SSD-88105458
Shoalhaven City Council Response to Request for Comments – SEARs

I refer to the Department of Planning, Housing, and Infrastructure's request for comment in relation to a request for SEARs regarding the 'St Georges Basin Residential Flat Building' development located at Anson Street St Georges Basin (Lots 1 & 6 DP 1082382).

Site Plan with Overall Concept Building Footprint
1:500

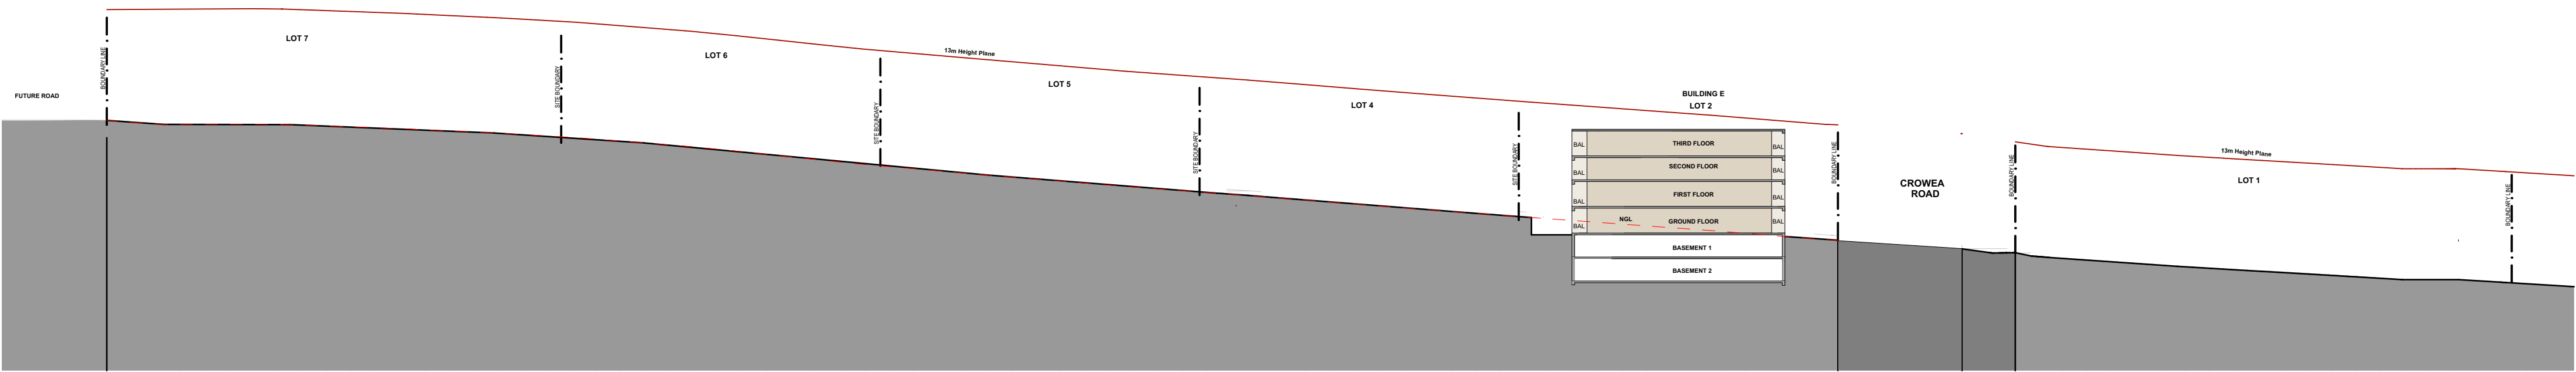
- It is noted that both proposed roundabouts and the proposed pedestrian crossing are all shown on the preliminary plans (albeit crudely), however given the now staged approach of the development, the roundabout at Anson Street/Crowea Road (in addition to the proposed pedestrian crossing) is likely to be required to mitigate this initial stage of development, where as it may be appropriate to defer the eastern most roundabout to a later stage of development.

- Setbacks of the development to the adjoining manufactured home estate development to the south. The plans do not demonstrate tiering of setbacks equivalent to that consented to as part of the approved development on Lot 25.
- Further consideration must be given to solar access and overshadowing to adjoining development to the south. The development should not have an adverse impact to adjoining developments and should allow sufficient solar access consistent with the requirements of the Apartment Design Guide.
- Privacy – The privacy of the adjoining developments shall be further considered in the design – including any features such as use of reeded glass, privacy screens, etc, to minimise privacy impacts.
- Consideration of noise impacts associated with any public spaces and the requirement for an acoustic report.

Drawing Name
CONCEPT BUILDING ENVELOPE & SECTIONS

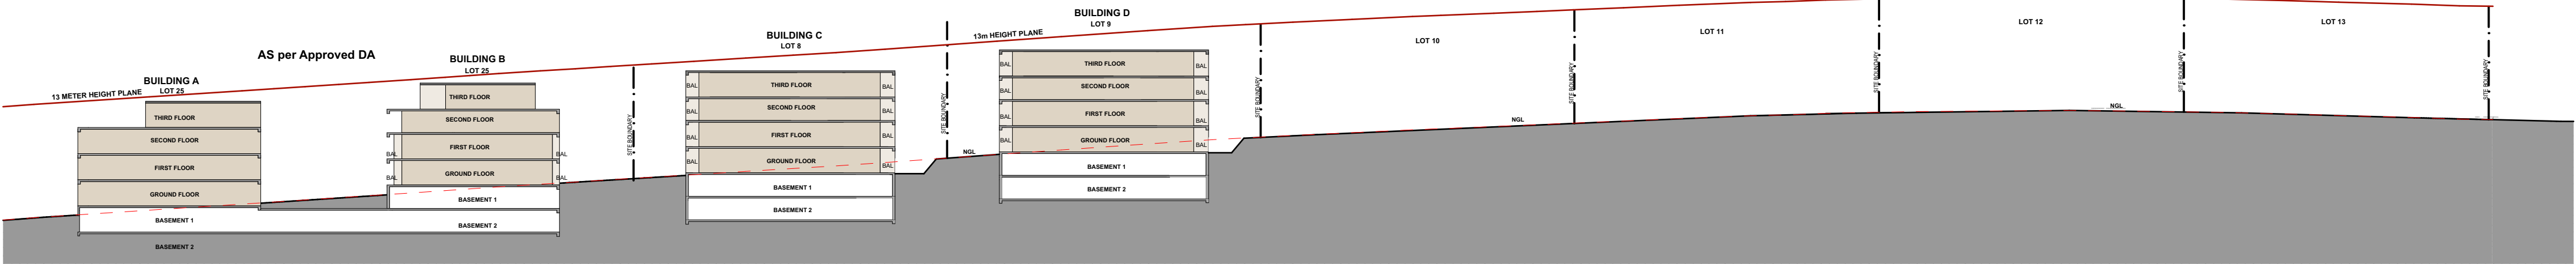
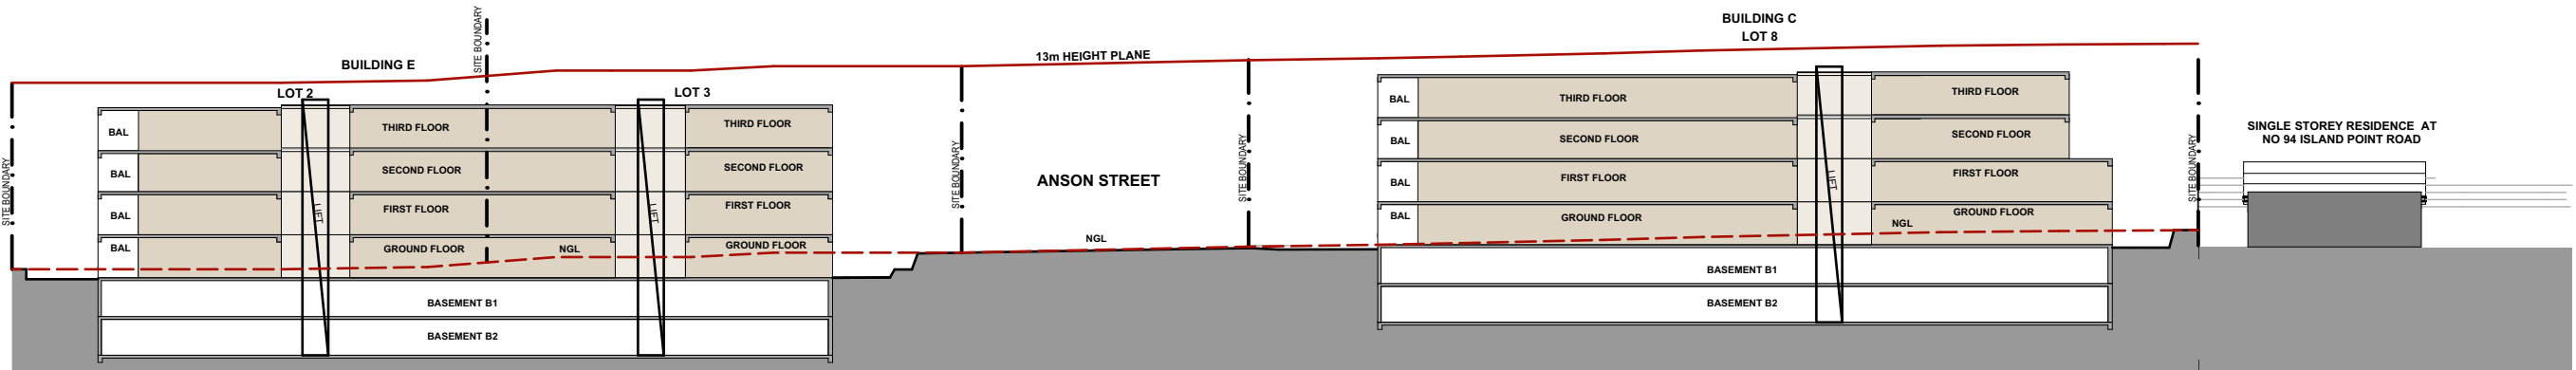
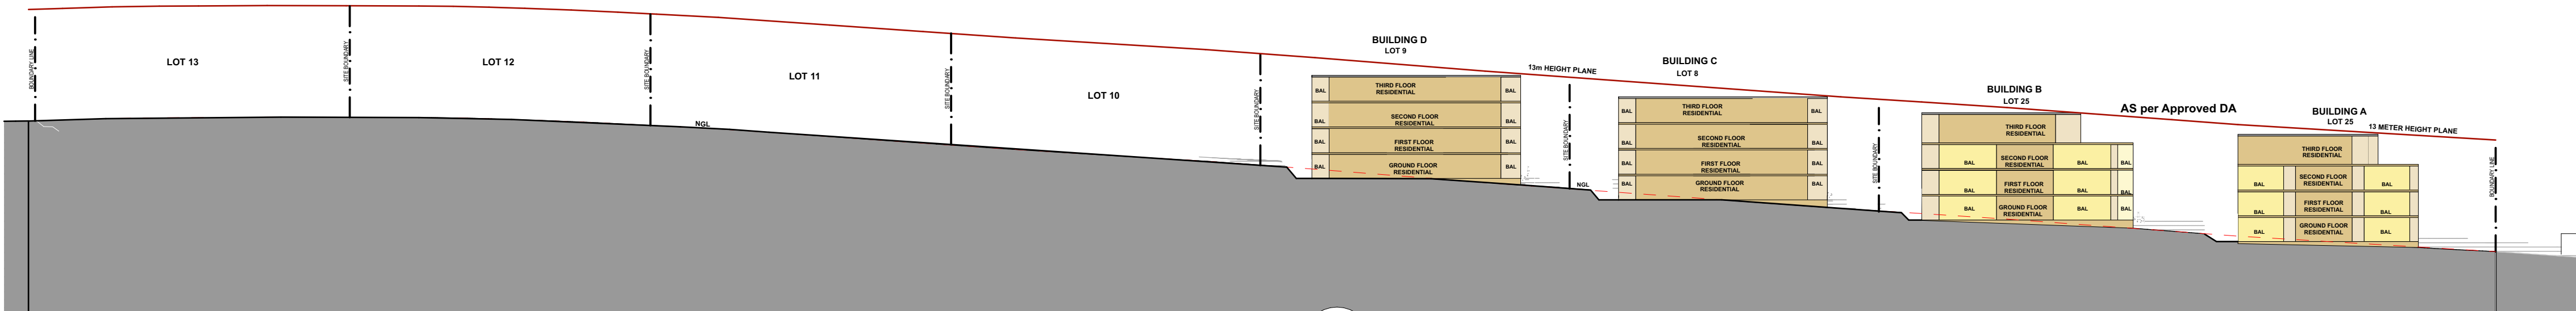
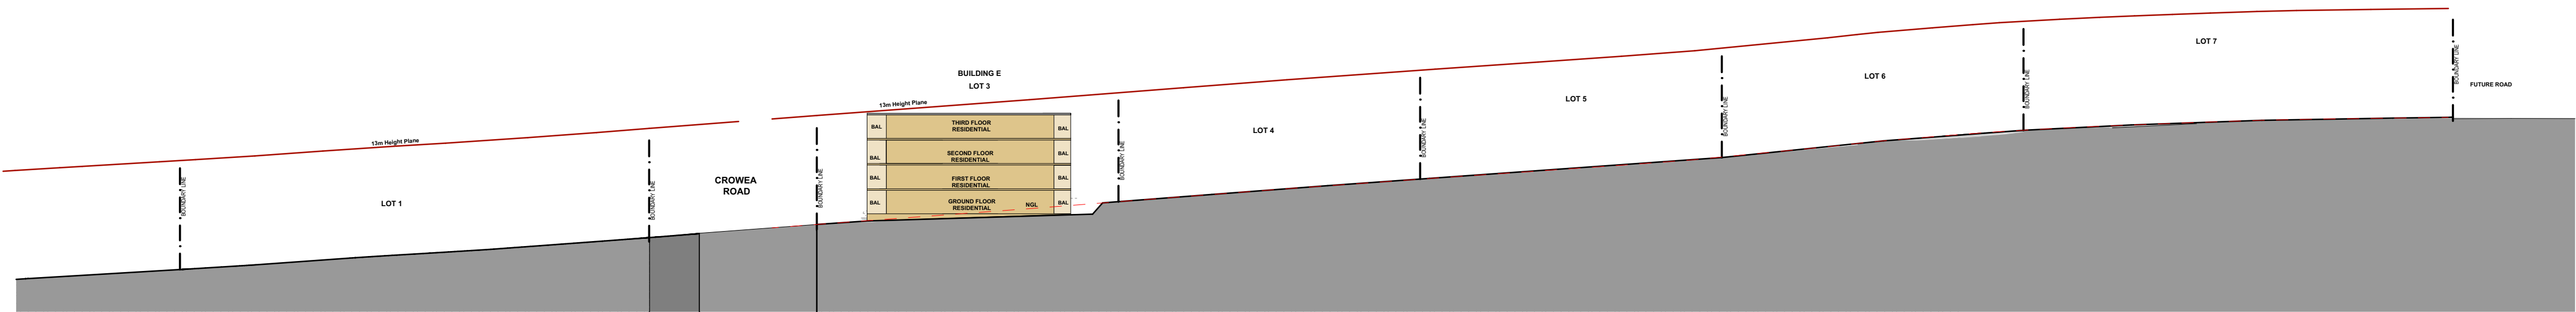
It is noted that the proposal that is currently before us again proposes a 13 metre height limit. This is at odds with the specific LEP amendment (No.25) that concluded in 2019 and was informed and supported by detailed Feasibility Assessment and Character Assessment and Urban Design Review. As a result the subject land is currently mapped in the LEP as having a height of buildings of 8.5 metres. The assessments referred to remain relevant and warrant due consideration as part of this matter – they are available [on line](#) as part of the Planning Proposal that resulted in LEP Amendment No.25.

The proposal and any associated amendment to the LEP need to fully consider the impact on the adjoining neighbourhood, its amenity and character. It is noted that development adjacent to this site is largely one and two storeys.
